CITY OF ALBUQUERQUE	
DRAINAGE	
DRAIN LINE THROUGH CURB	
DWG. 2235	
AUG. 1986	
REVISIONS

**Re: Assistance League of Albuquerque Drainage Plan  
Engineer Stamp 9-5-08 (J17/D30)**

PROJECT TITLE: Assistance League of Albuquerque - Curb Penetration ZONE MAP: J-17 D030  
/2007  
DRB#: \_\_\_\_\_ EPC#: \_\_\_\_\_ WORK ORDER#: \_\_\_\_\_

Drainage Solution
Plan View & Details

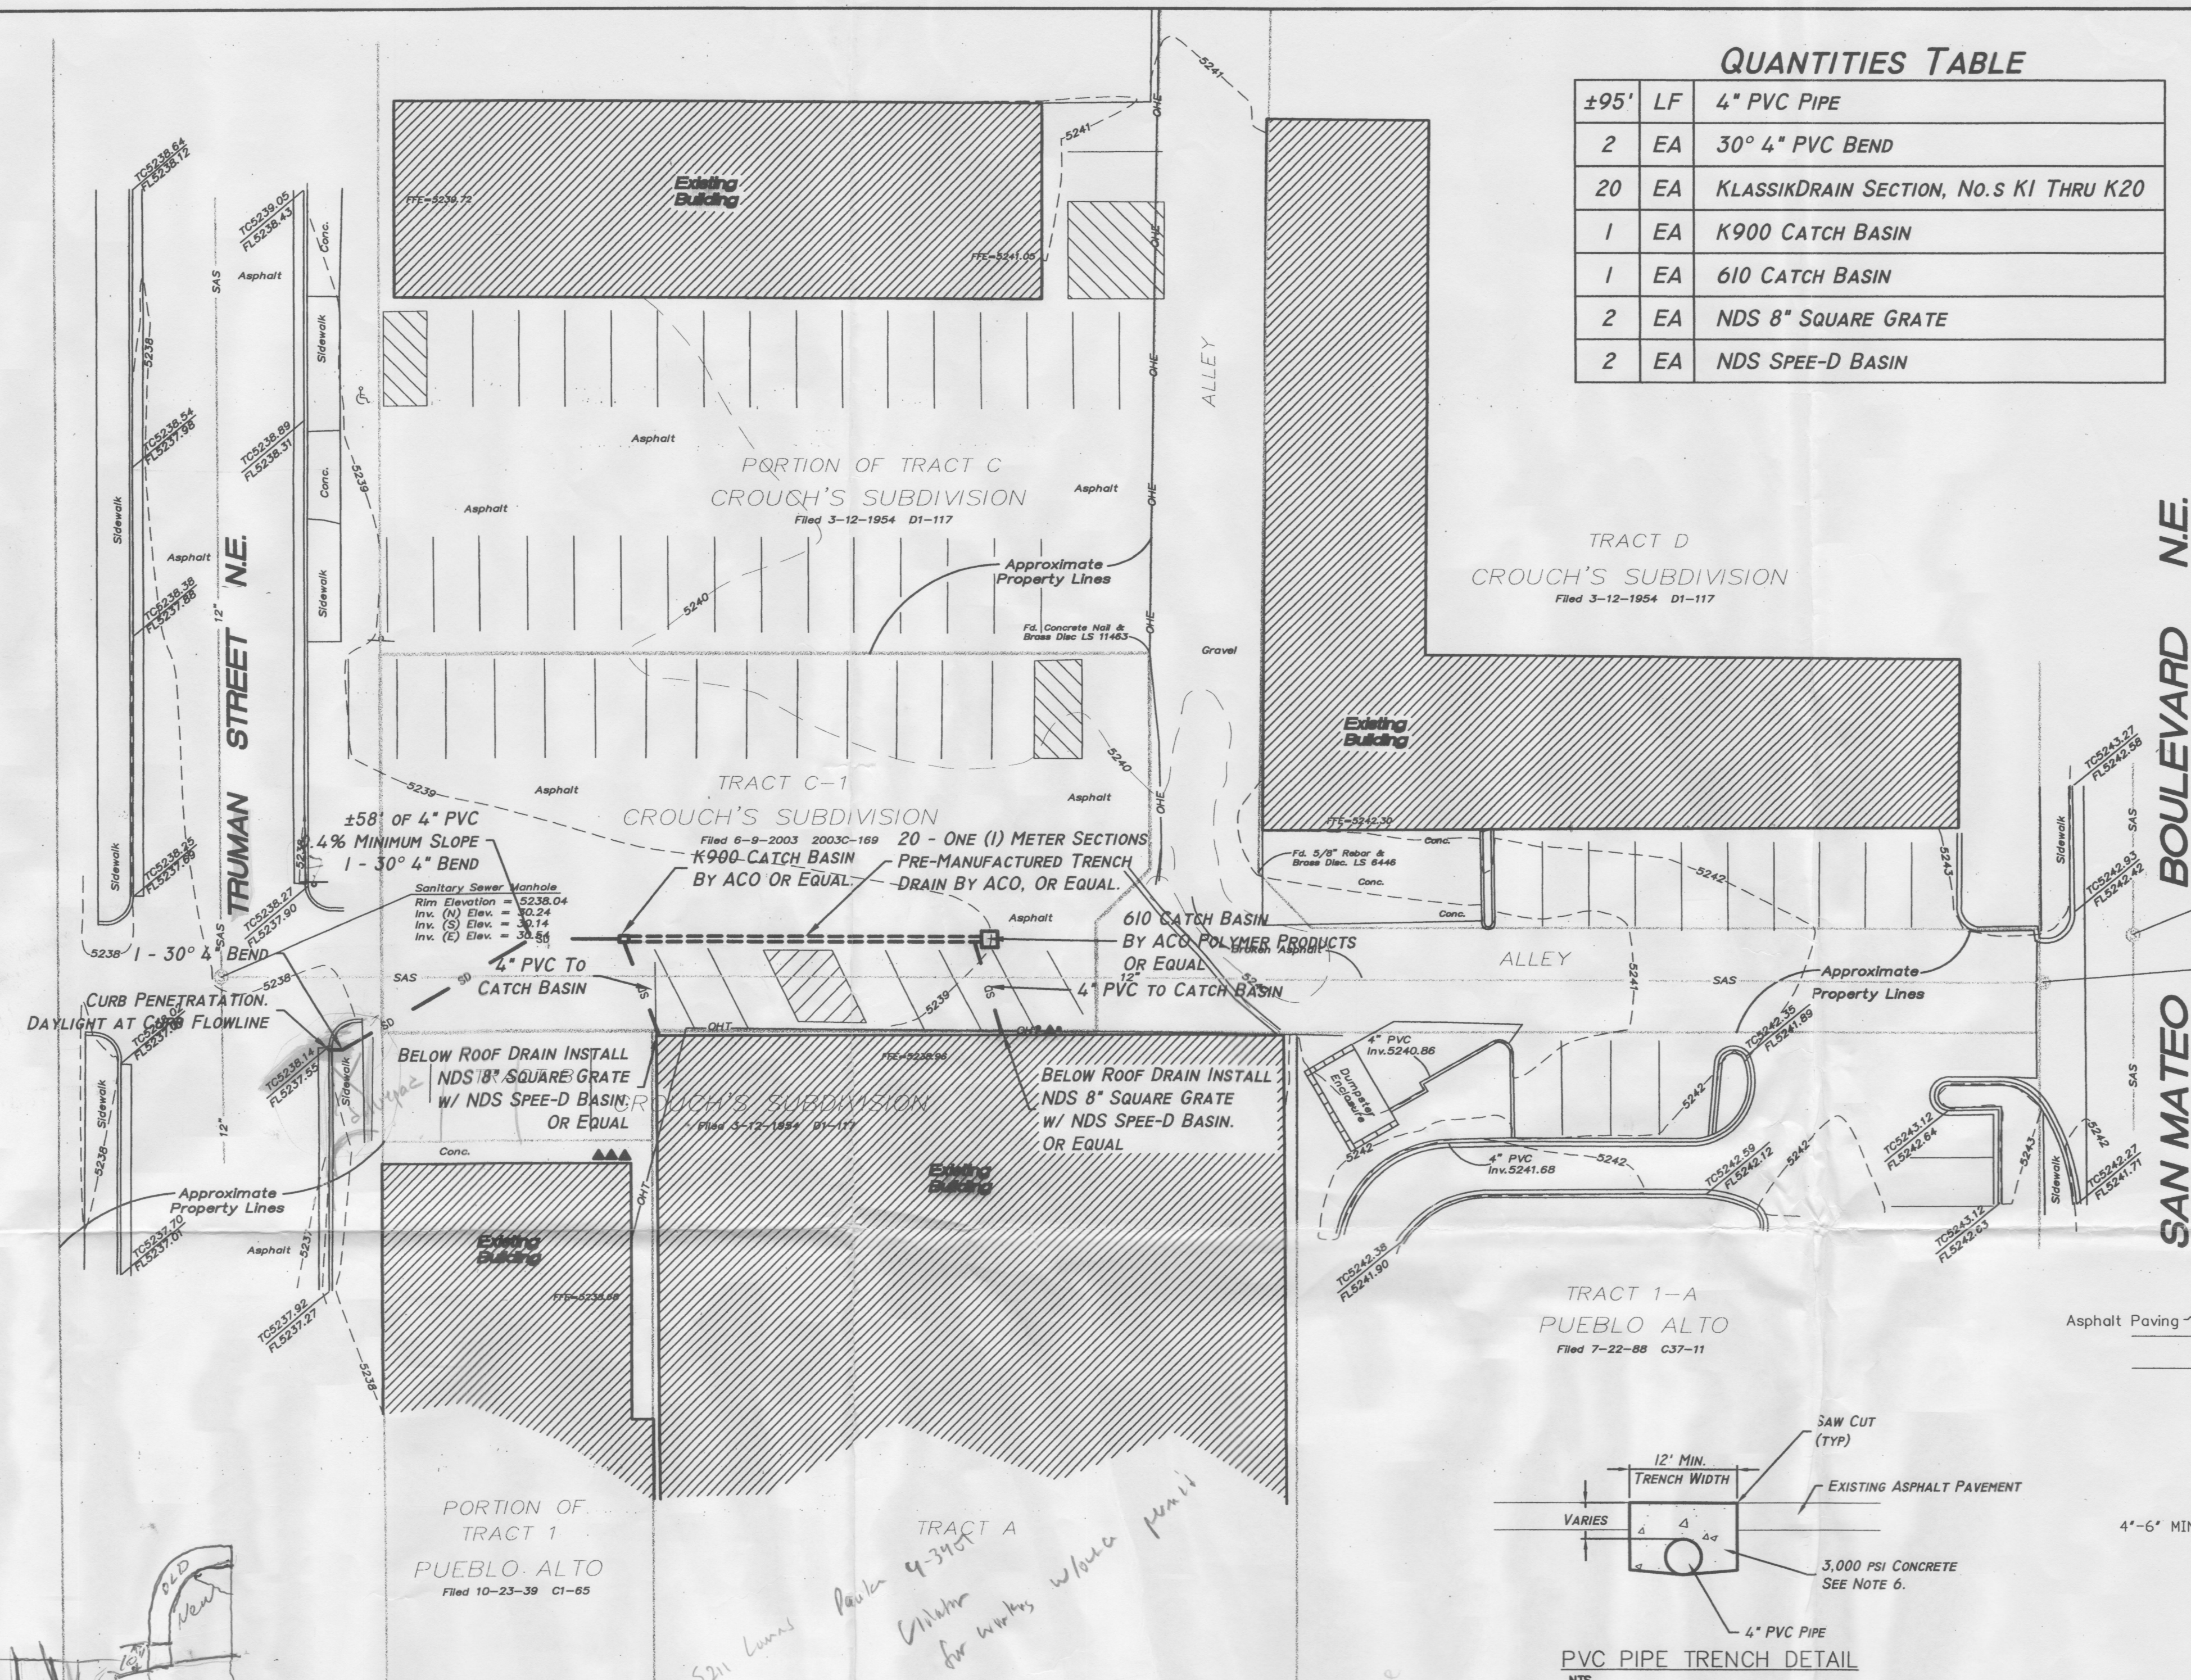
Deane Schmitt called  
to report a sub standard  
50-10 inspection on Treason st  
100' north of Lones Blk.  
The drain line thru the curb  
was not built to city std 2235  
due to the site conditions.

Charles and I agree that  
the drain line was not built  
per con std Dwg 2235.

contacted the property owner  
to the South to close  
part of the drive entrance  
to the South so this could  
be built to 2235 but the  
property owner to the South  
did not want to close  
part of drive entrance, And  
if this fails, per 5019  
the property owner will  
have to fix it.

Therefore I contacted Deane  
Schultz DND and told  
him that Hydrology would  
accept this condition.
